**CITY OF ALBUQUERQUE  
ADMINISTRATIVE APPROVAL (AA)- SITE DEV PLAN AMENDMENT  
REVIEW SHEET**

APPLICATION #: <b>AAA 10045</b>	PROJECT #: <del>1002962</del> <b>1002962</b>
PROJECT NAME: <b>Lantata at the Trails</b>	
APPLICANT or AGENT: <b>Consensus Planning</b>	
PHONE # and E-MAIL: <b>764-9801</b>	
ZONE ATLAS PAGE: <b>C-9</b>	
ADMINISTRATIVE APPROVAL (AA) for:	<input type="checkbox"/> EPC CASE <input type="checkbox"/> DRB CASE

RE: Administrative Amendment for Cantata at The Trails, Lot B, Cantata at The Trails Subdivision, Zone Map Page C-9

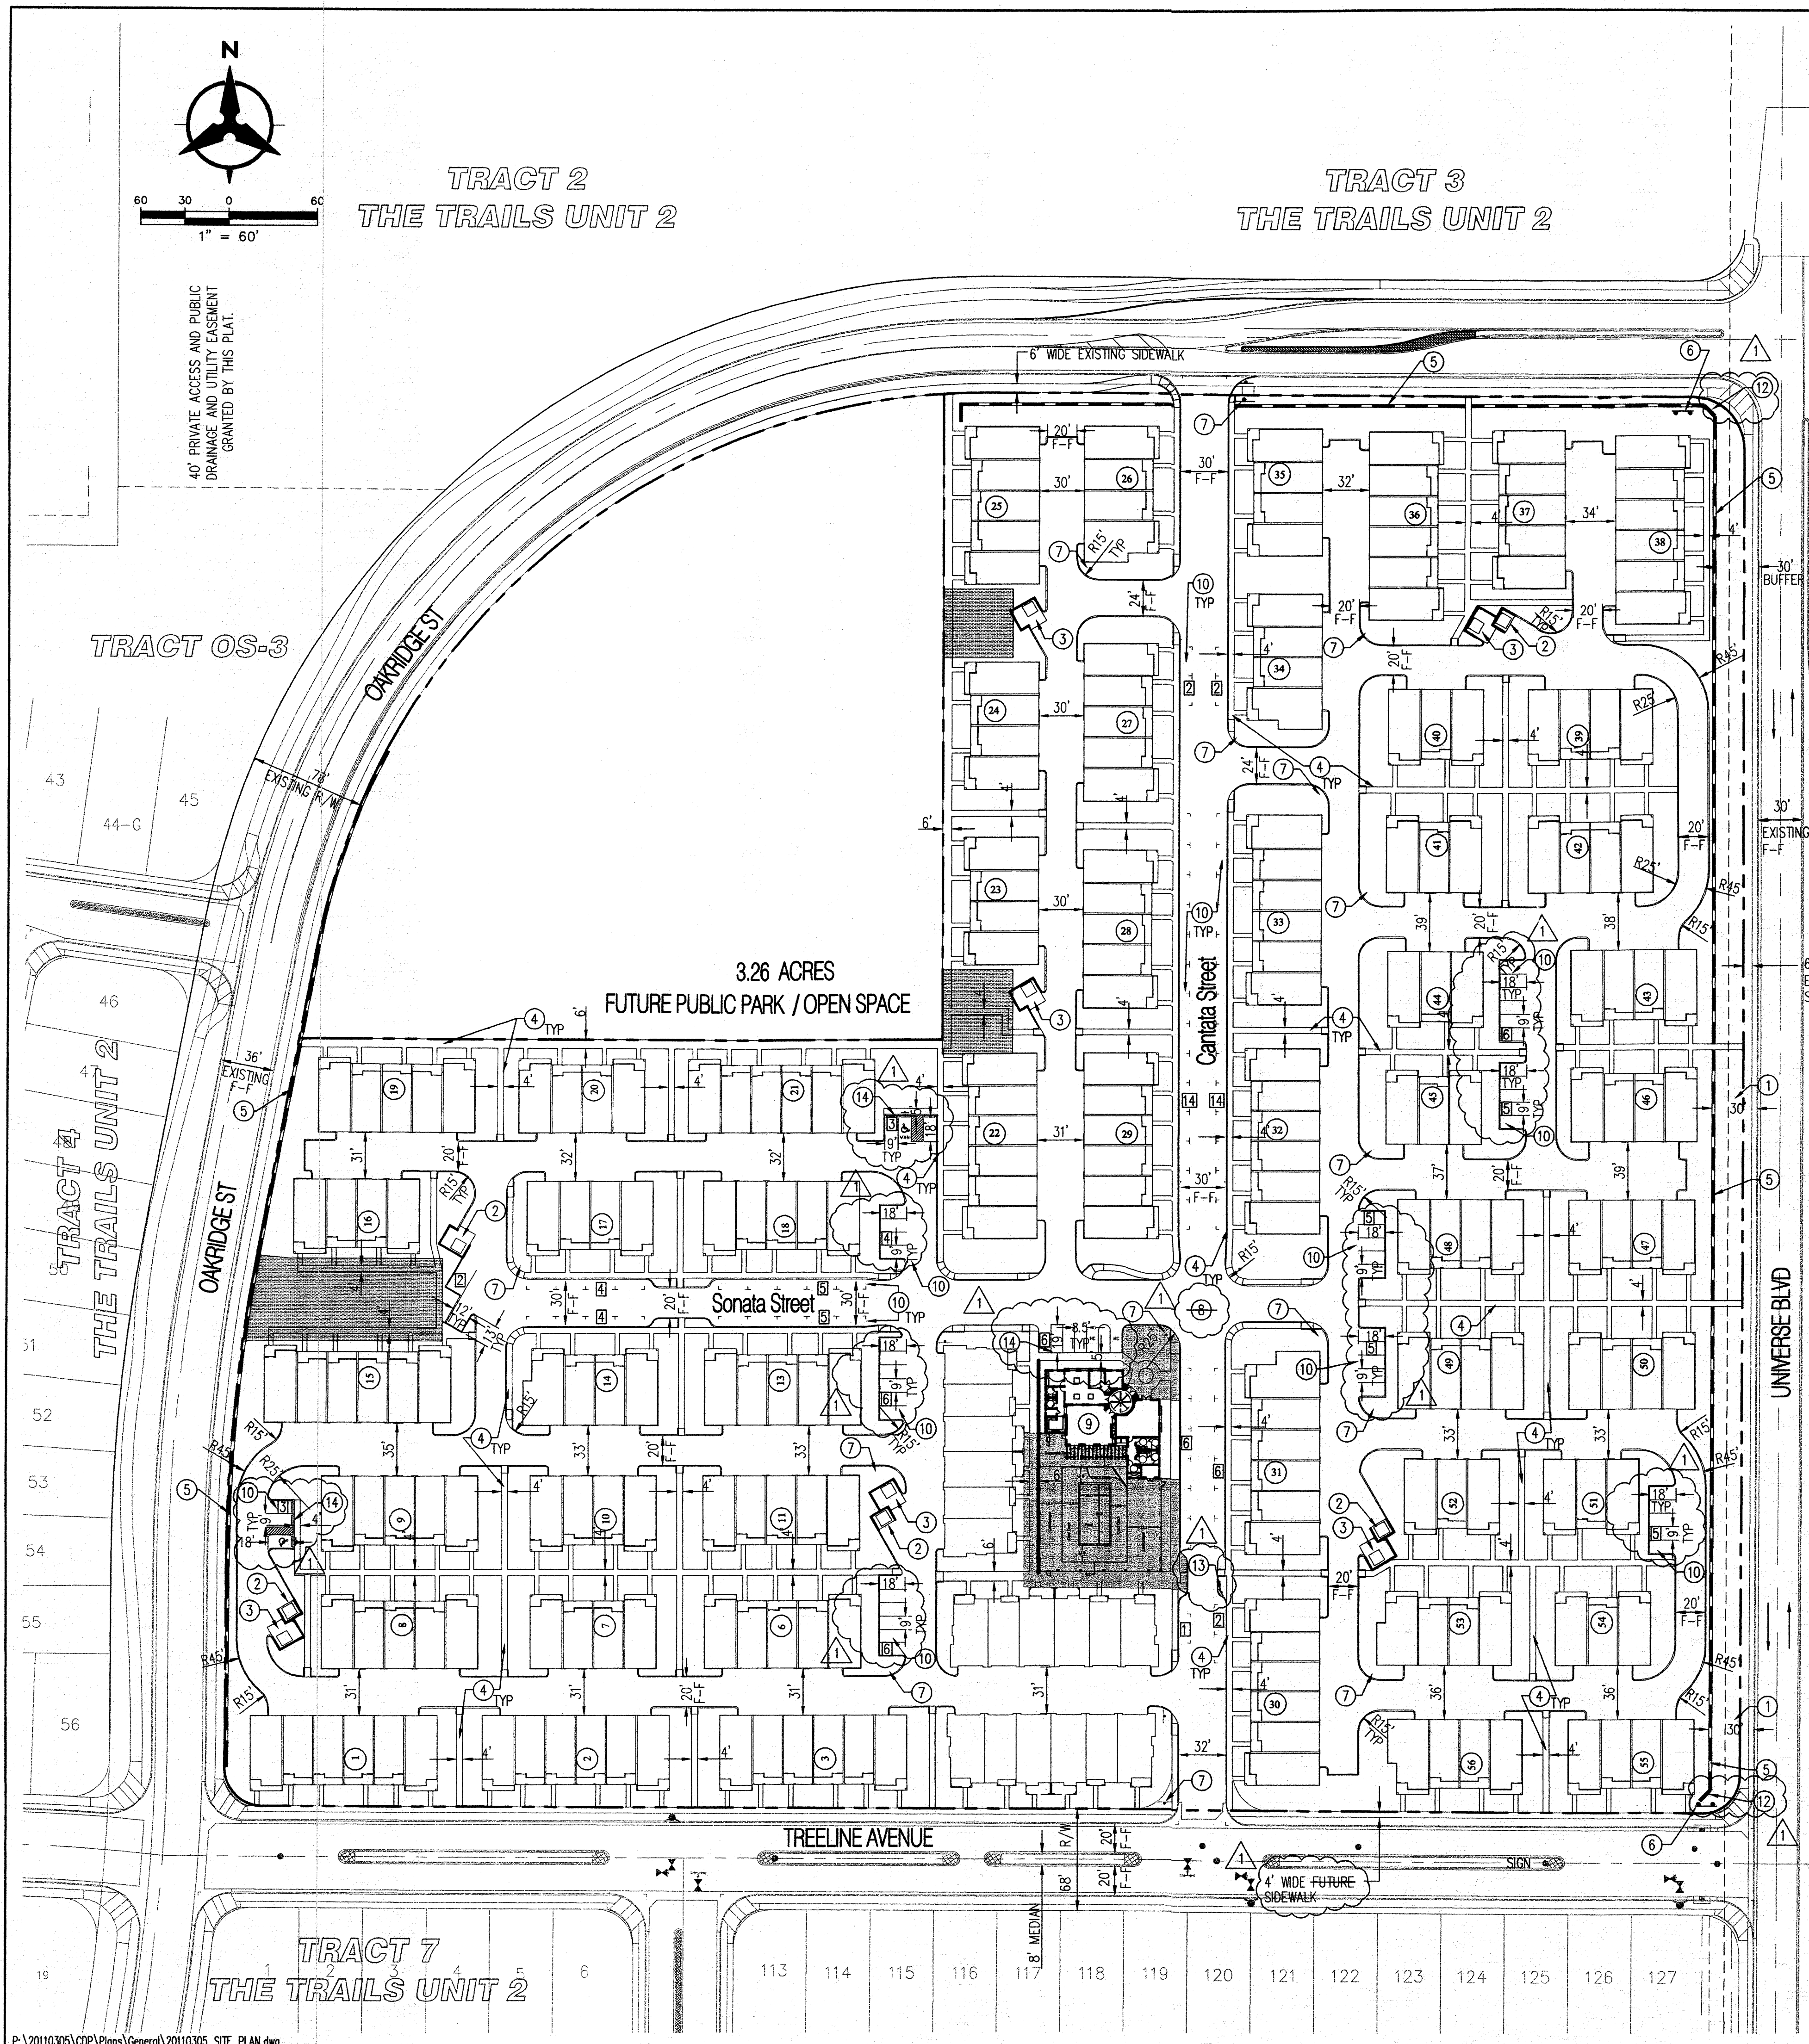
PLANS DISAPPROVED:	DATE: <b>NSF 04/22/11</b>	DATE:
PLANS APPROVED:	DATE: <b>05/10/11</b>	DATE:
COMMENTS: <b>- NEED 6' MIN. CLEAR SIDEWALK PATH ADJACENT TO VEHICLE OVER HANG (PROVIDE &amp; LABEL)</b>		
<b>- DIMENSION STALLS @/FOR GUEST PARKING</b>		
<b>ALL</b>		
<b>- PROVIDES WC RAMP FOR ADA STALLS (LABEL)</b>

CONCEPTUAL GRADING AND DRAINAGE PLAN
FOR SUBDIVISION AND BUILDING PERMIT

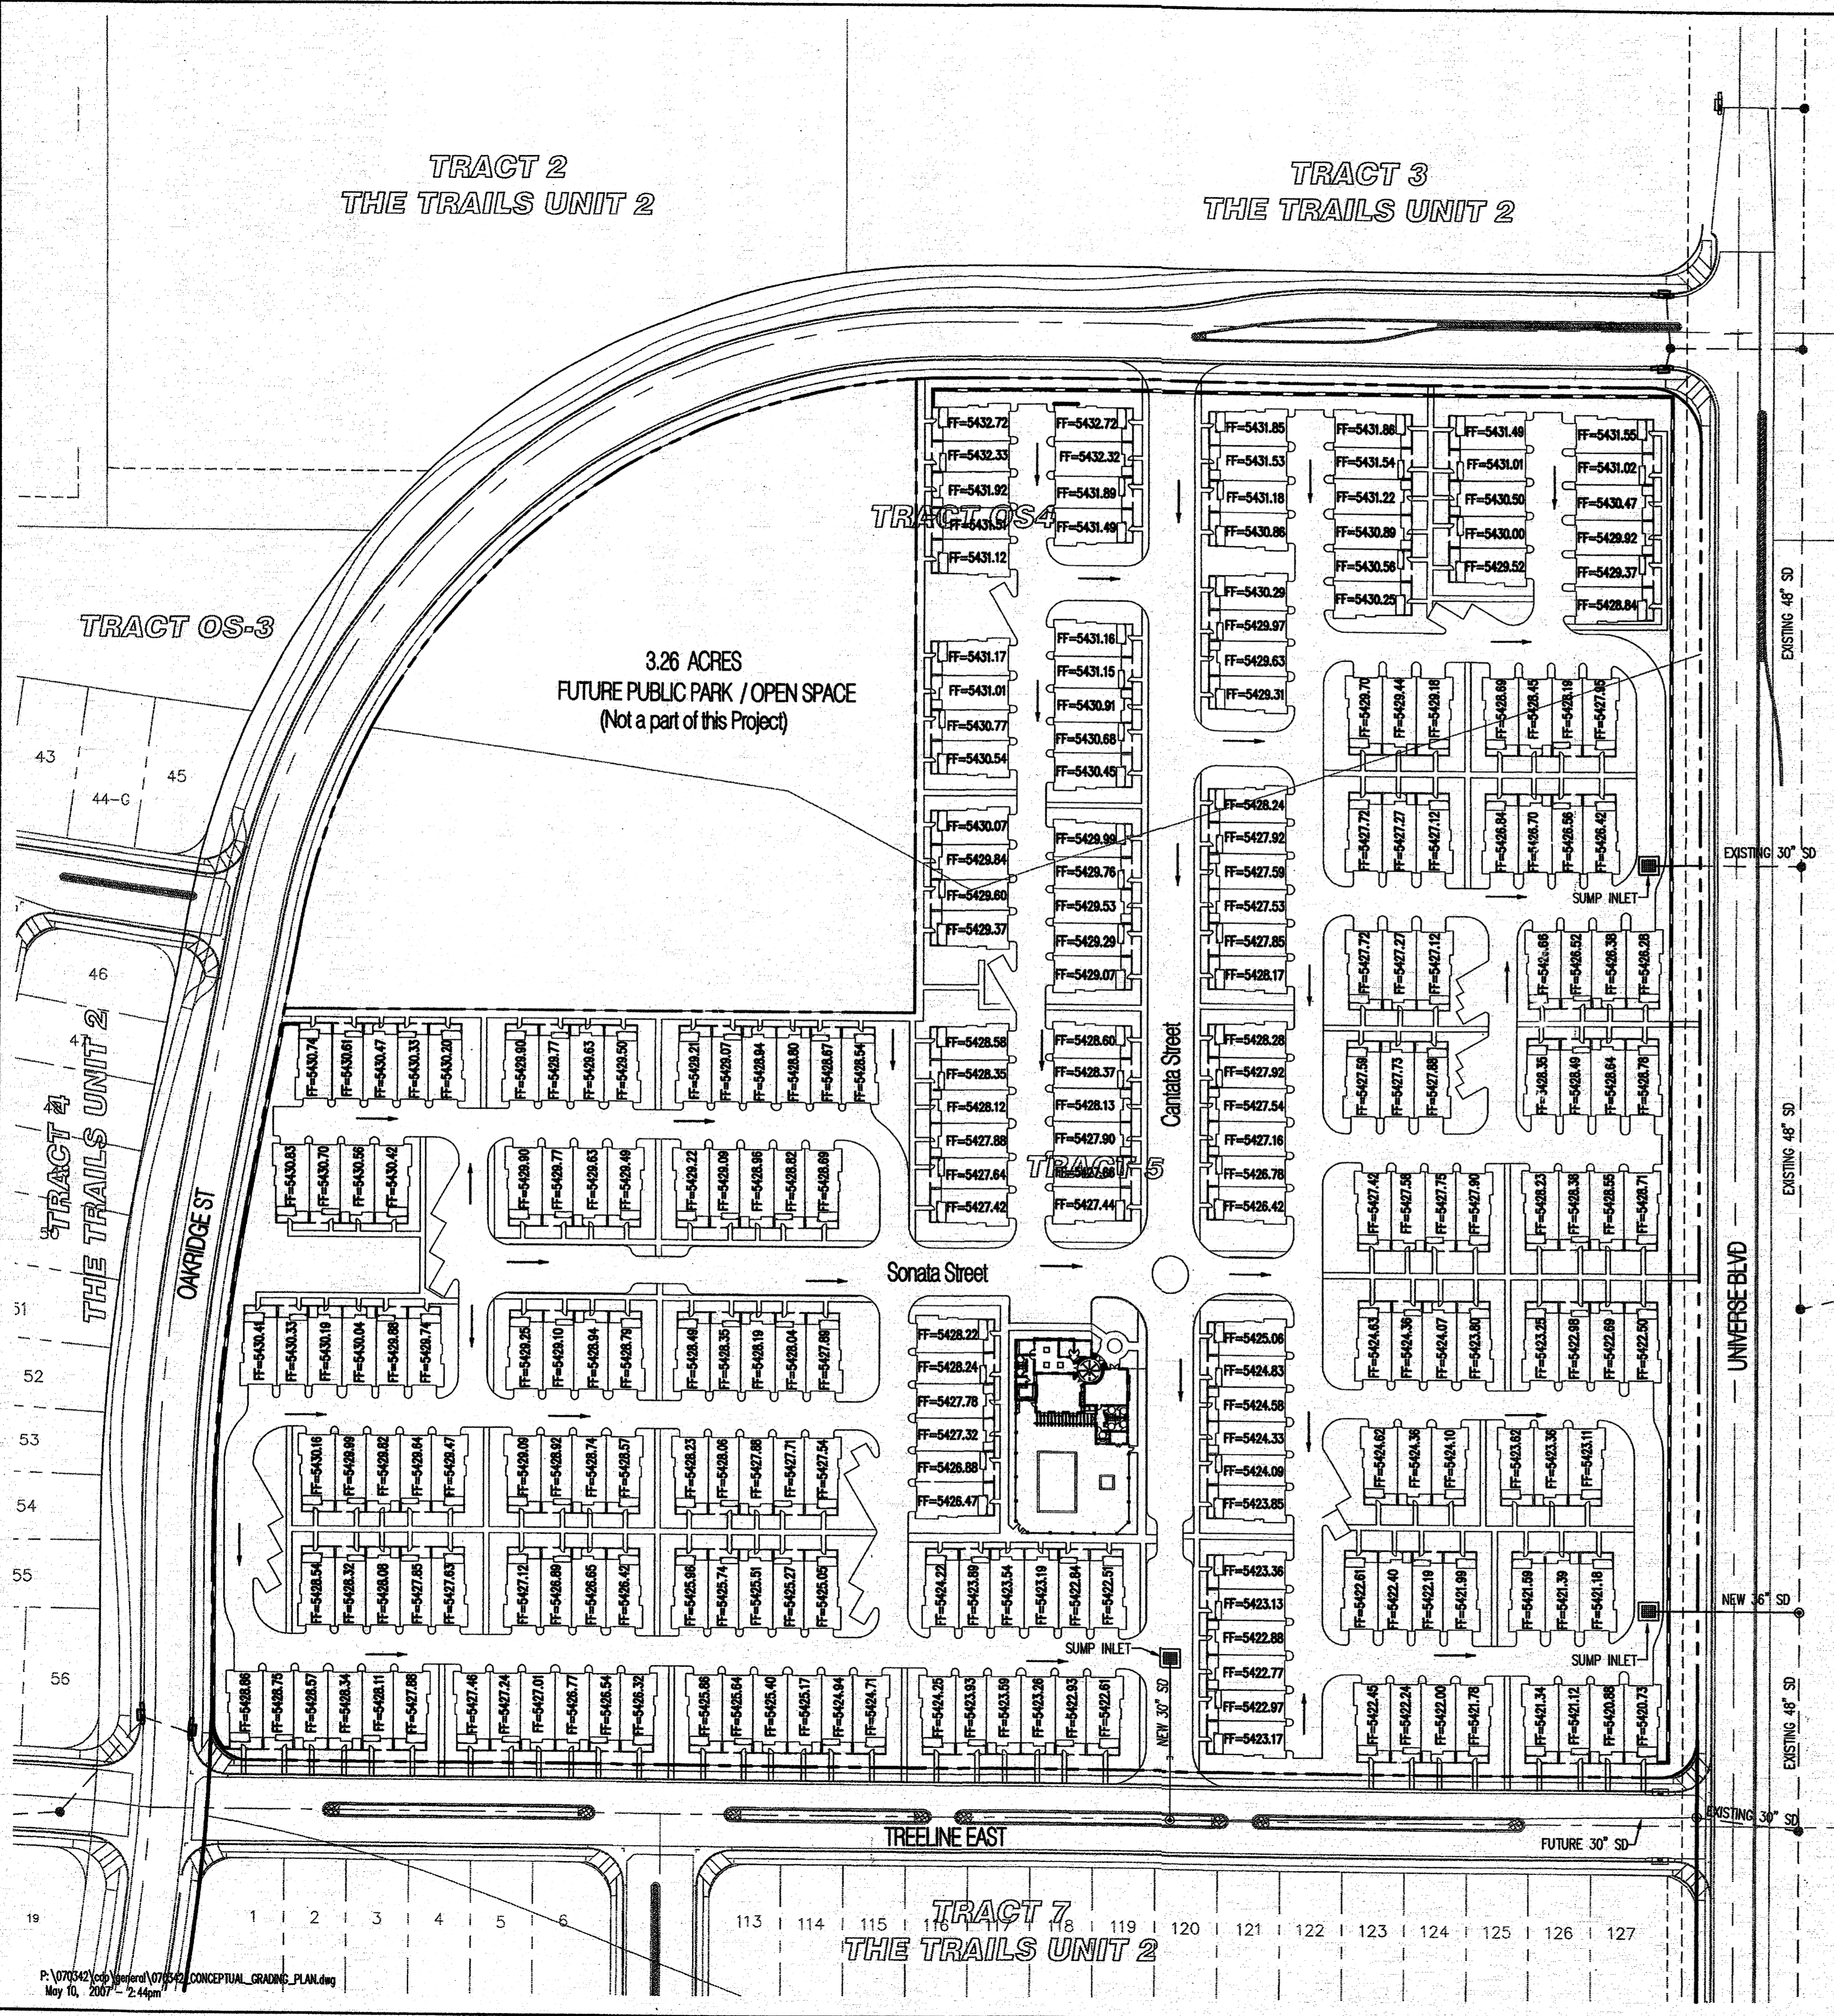
PLANS DISAPPROVED:	DATE: <b>4-26-11</b> <i>Center of City</i>	DATE:
PLANS APPROVED:	DATE: <b>5-16-11</b> <i>Center of City</i>	DATE:
COMMENTS: <b>It is not clear how or where the building types will be modified. Provide a typical lot and cluster so Hydrology can determine if a revised Grading plan is required.</b>
